## Questions & Answers

Legal/Request Descriptions & Location: 336 Woodward Road SE Albuquerque NM 87102

LANDSCAPE PLAN
MOVIE FILM STORAGE
336 WOODWARD AVE SE
ALBUQUERQUE, NM 87102

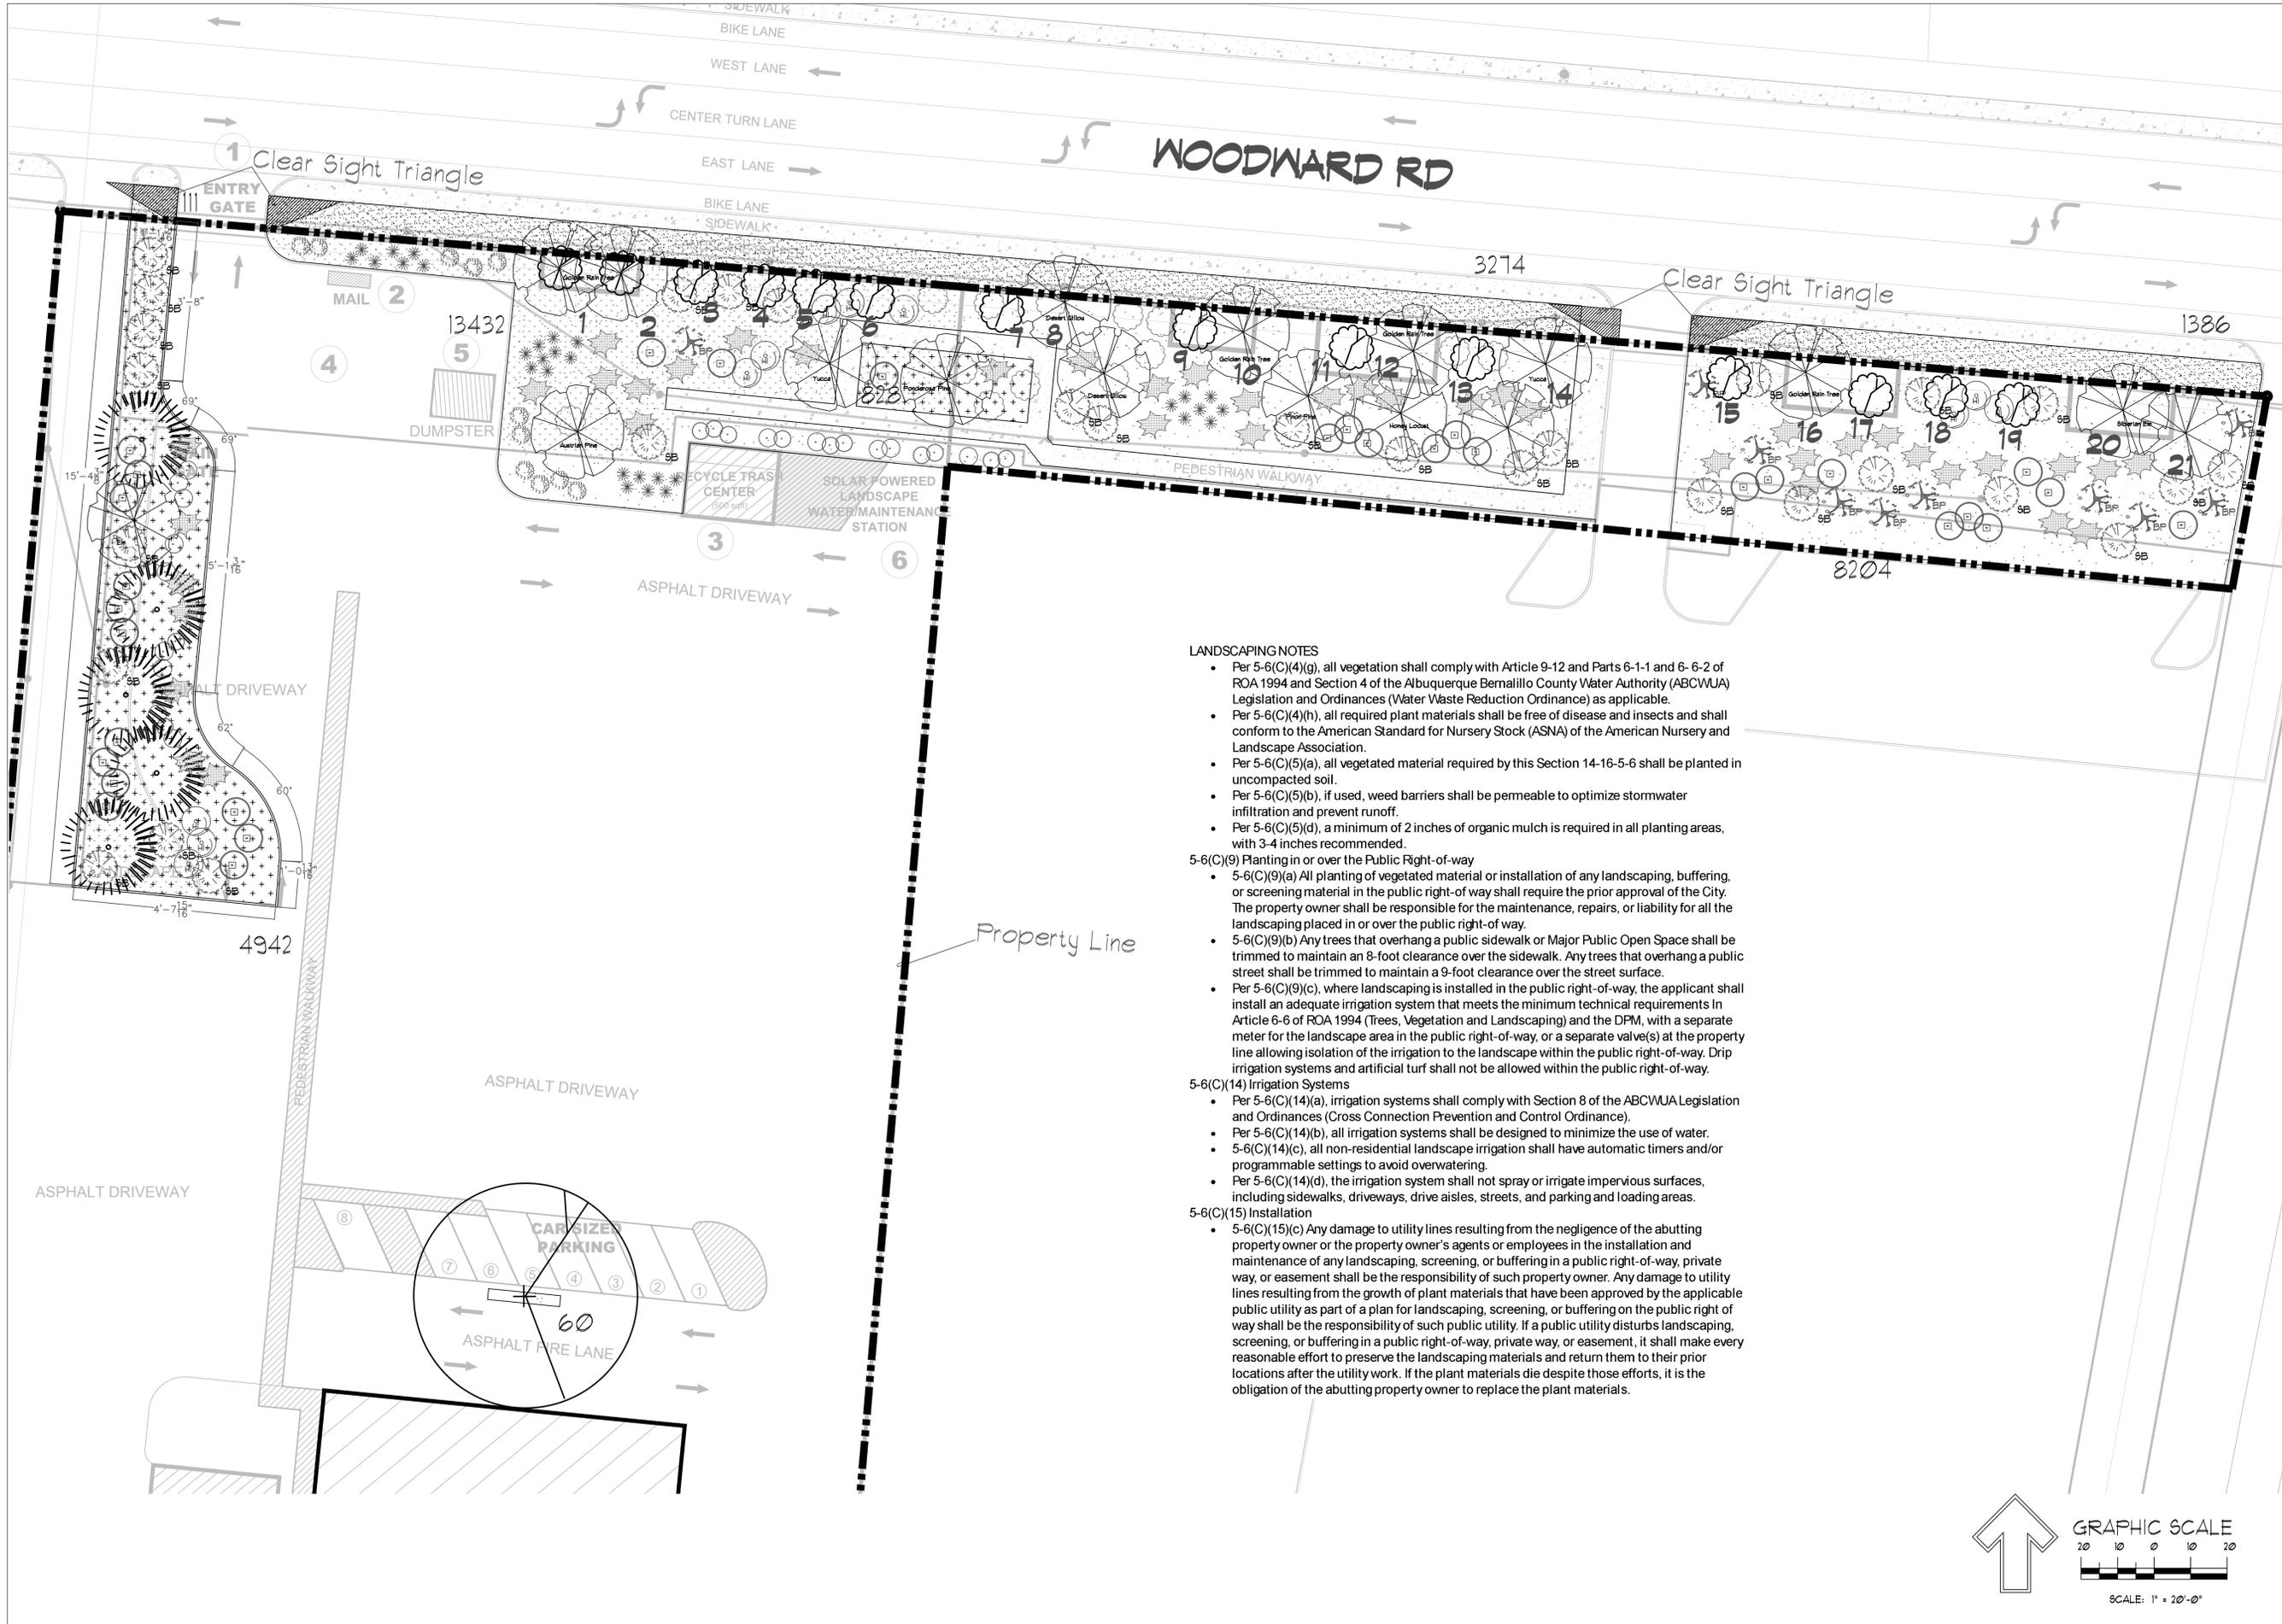
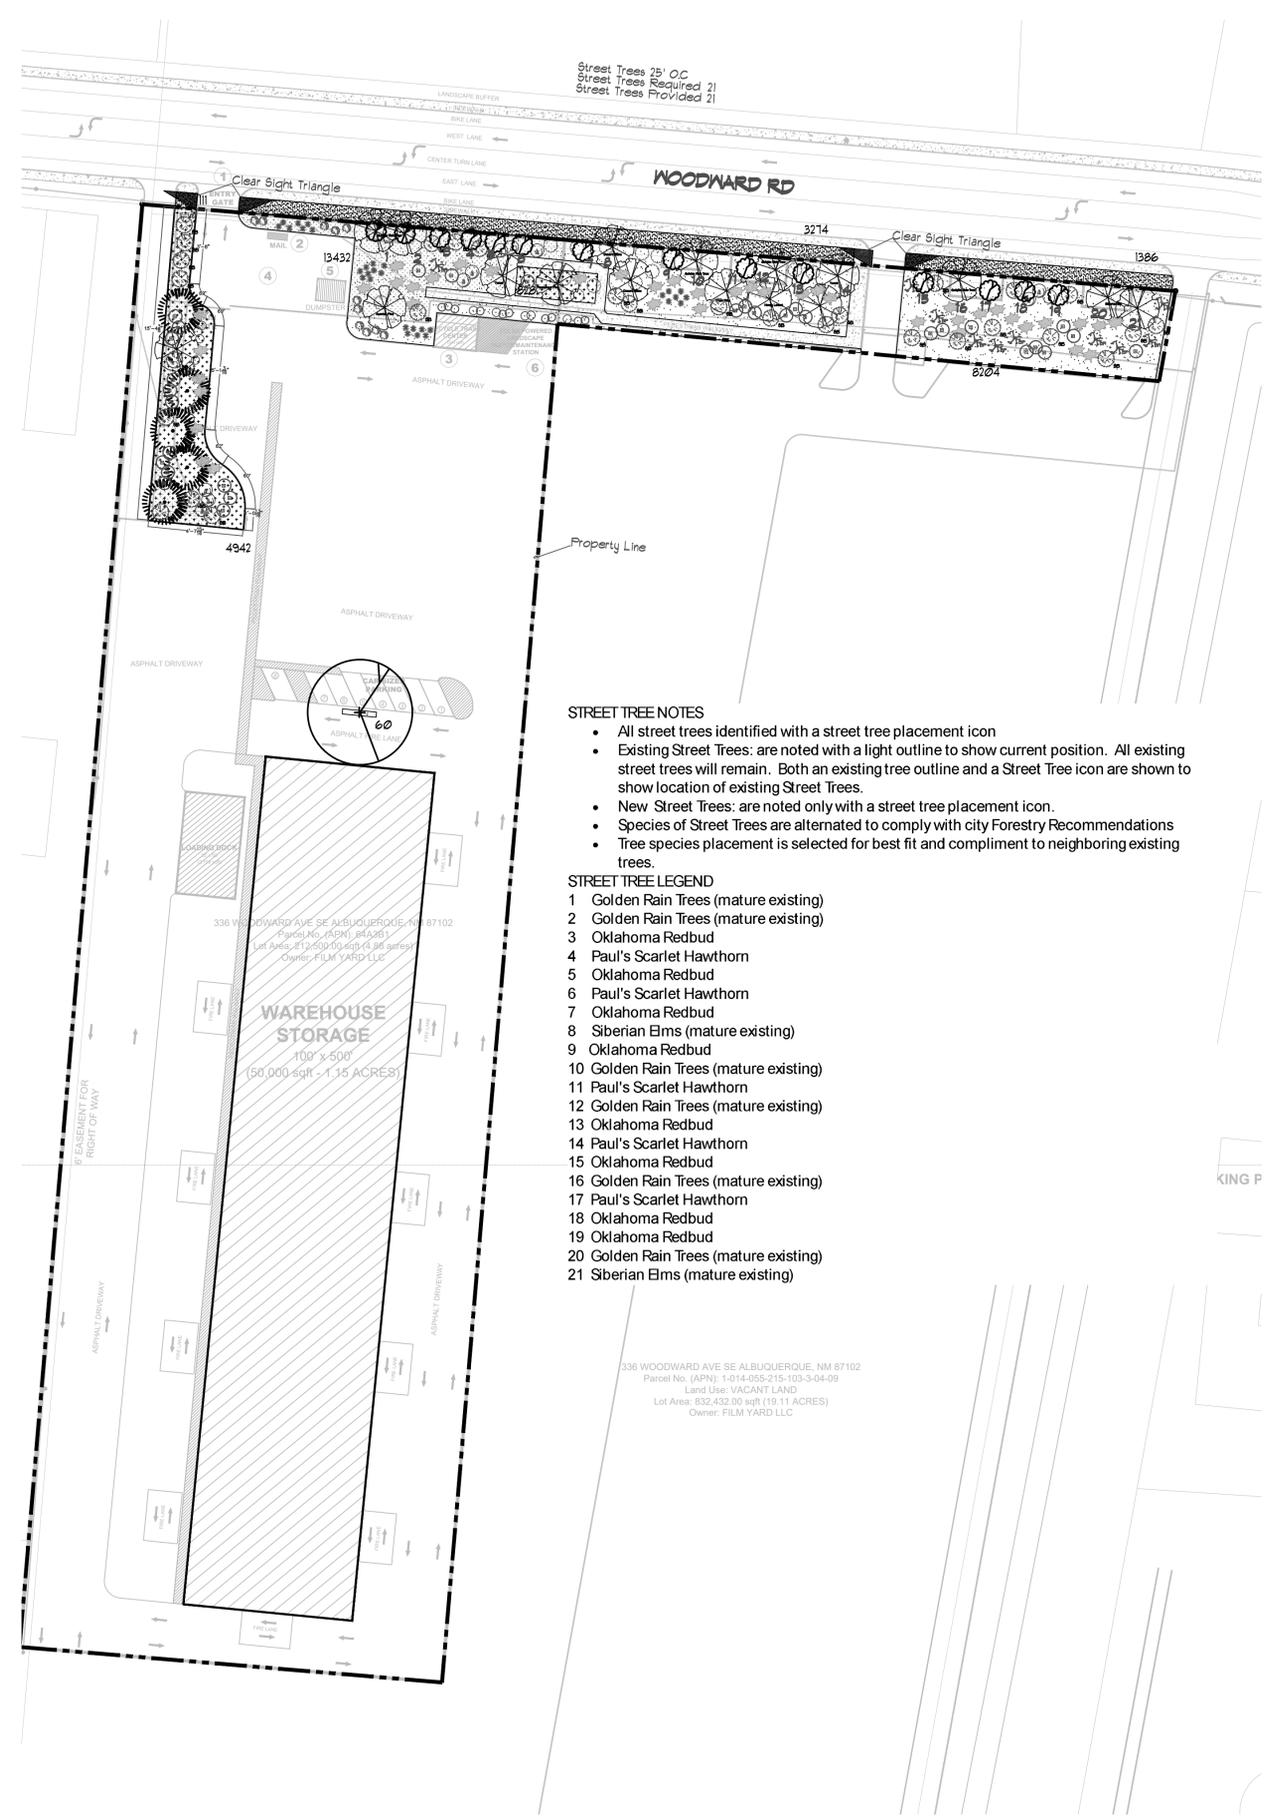
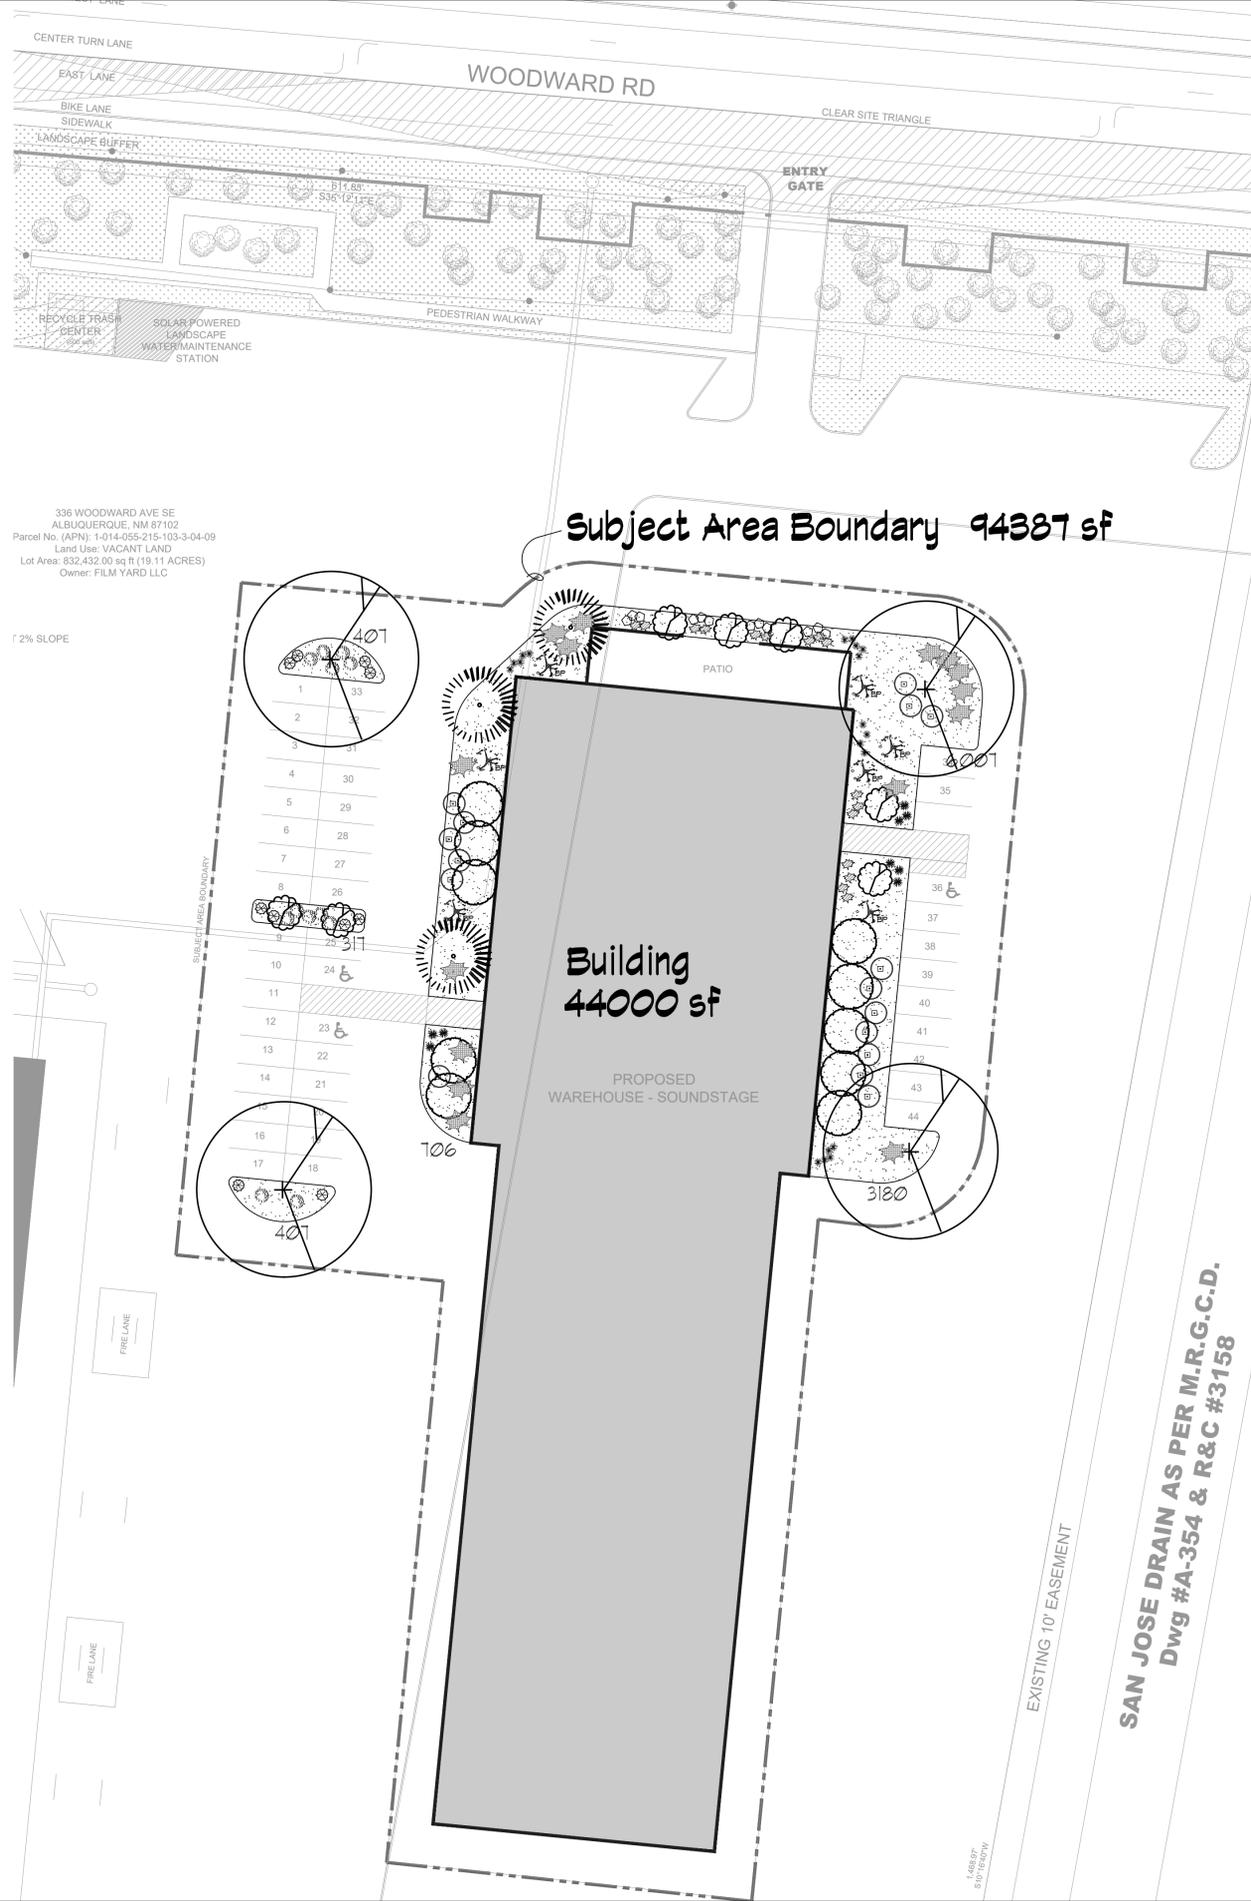
### **-Is landscaping changing? There were two separate plans in your revised file.**

Existing landscaping is not changing. New landscaping will be added. EPC requested both the old plan, the new plan for additional landscaping, and a consolidated plan that shows both. That is what you have as well.
